Planning and Regulatory, G.Mansfield
Reference: PB2016/11689
Phone: 02 4974 2767

13 December 2016

**NOTIFICATION OF DEVELOPMENT APPLICATION PORT OF NEWCASTLE P/L
USE OF DYKE POINT SHED CARRINGTON (DA8062)**

dwg ref: 239417-SITE-002-B

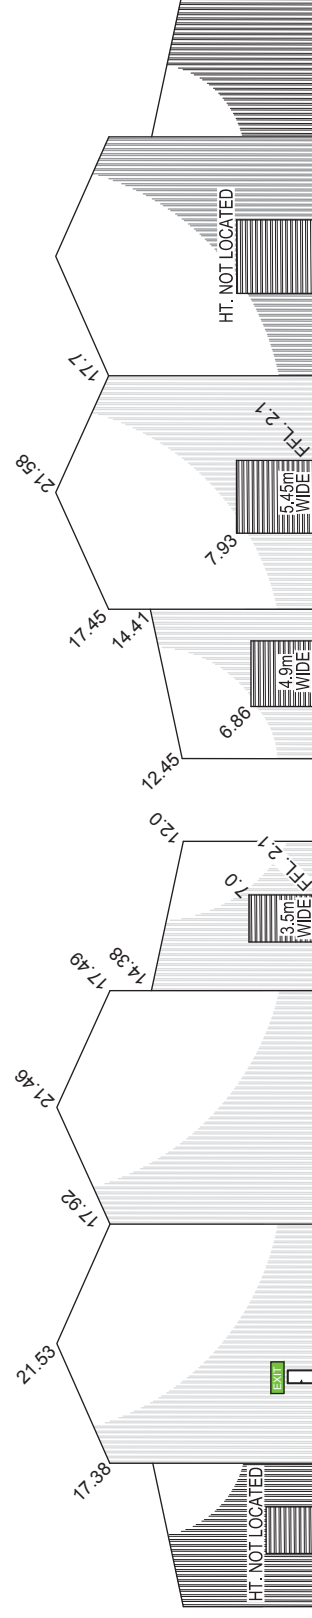
The SEE is silent on the number of on-site parking spaces available for use by staff and visitors of the future tenants of the shed. It is recommended clarification is sought from the applicant regarding this matter. The location of these parking spaces should also be indicated on the required development plans.

dwg ref: 239417-SITE-001-C

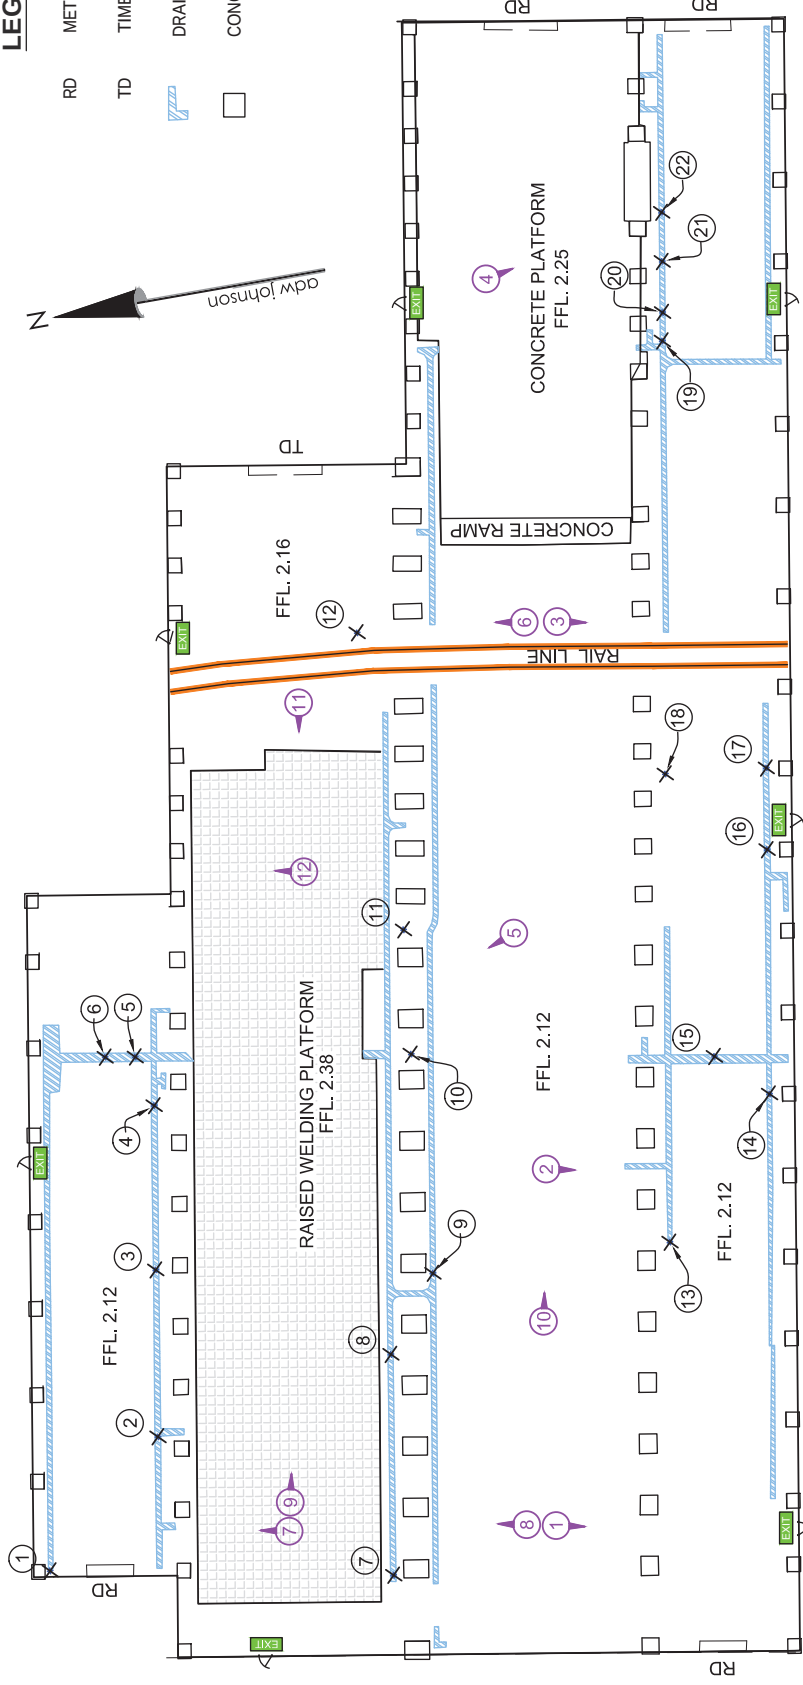
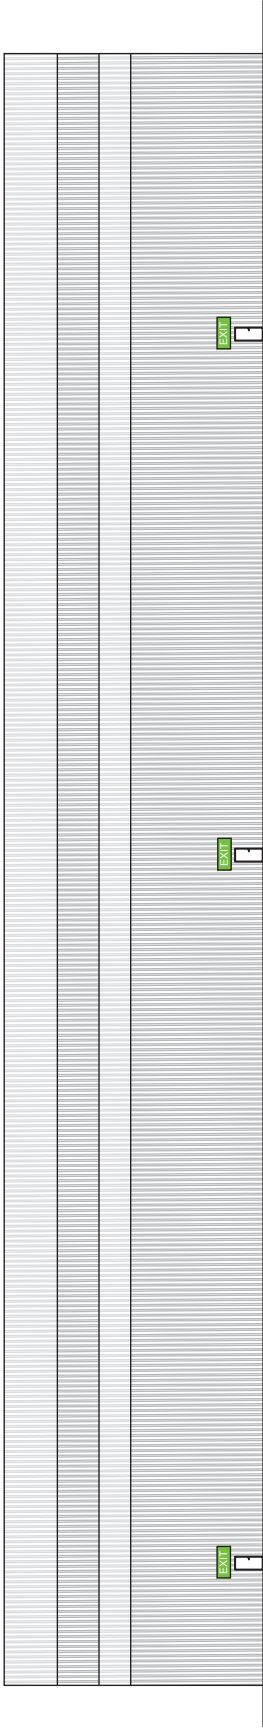
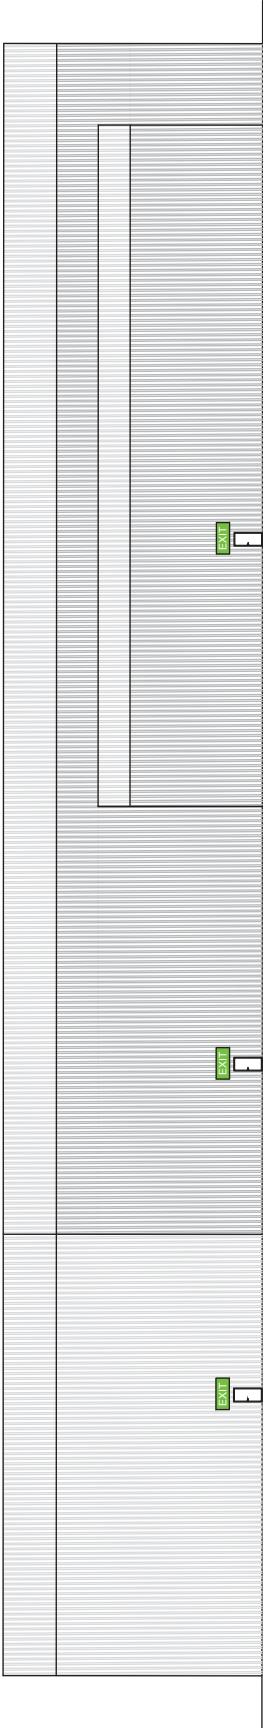
Plans and elevations of the shed were not included in Appendix B of the SEE. It is recommended the applicant is required to provide these drawings prior to determination of the application.
